Discharge of conditions 3 (noise management), 4 (external shutters) and 8 (party wall insulation) of planning application 2025/0245 which relates to the change of use of ground floor of existing newsagents (E) into a micro pub (Sui Generis).

34 High Street, Grimethorpe, Barnsley, S72 7LP

I refer to the above referenced discharge of condition application and to the Party Wall Noise Solution; Roller Shutters Example Drawing; Noise Management Plan and covering letter submitted to support the application.

Drawing Title:
Party Wall Noise Solution

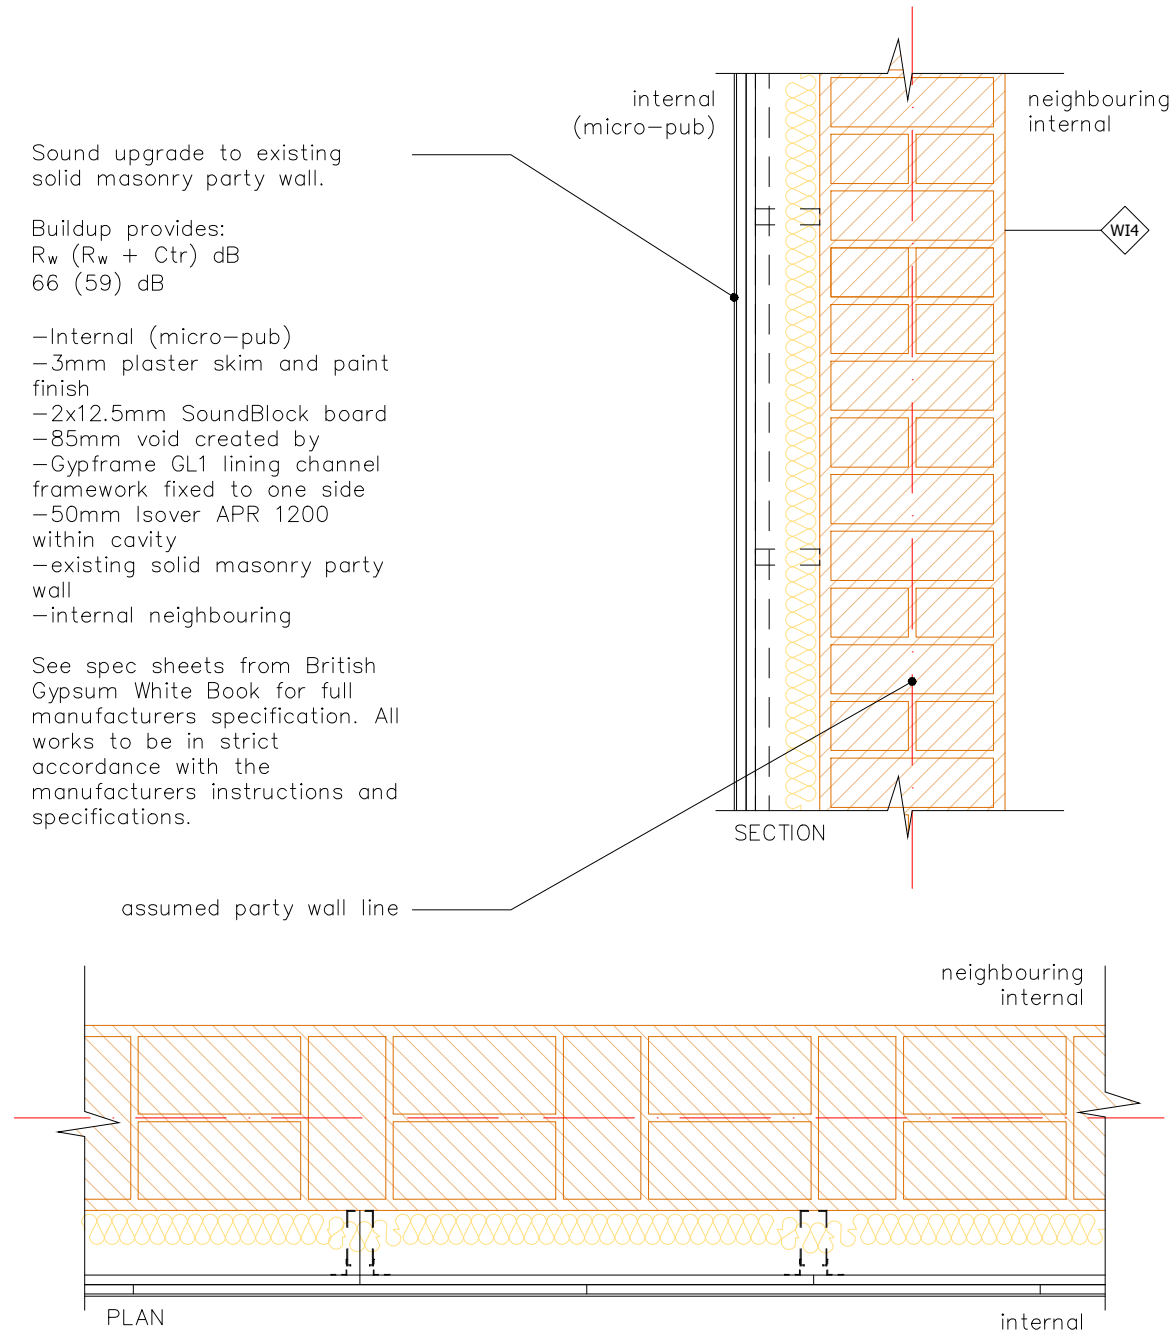
Condition 8 does not require discharge before the works are completed. I am content with your confirmation that the works will comply with Approved Document E – Resistance to the Passage of Sound but the condition requires evidence that the walls and ceiling have been insulated to the standards set out in the building regulations and Approved Document E. On completion of that work, the evidence should be submitted to the Council for discharge before the use commences.
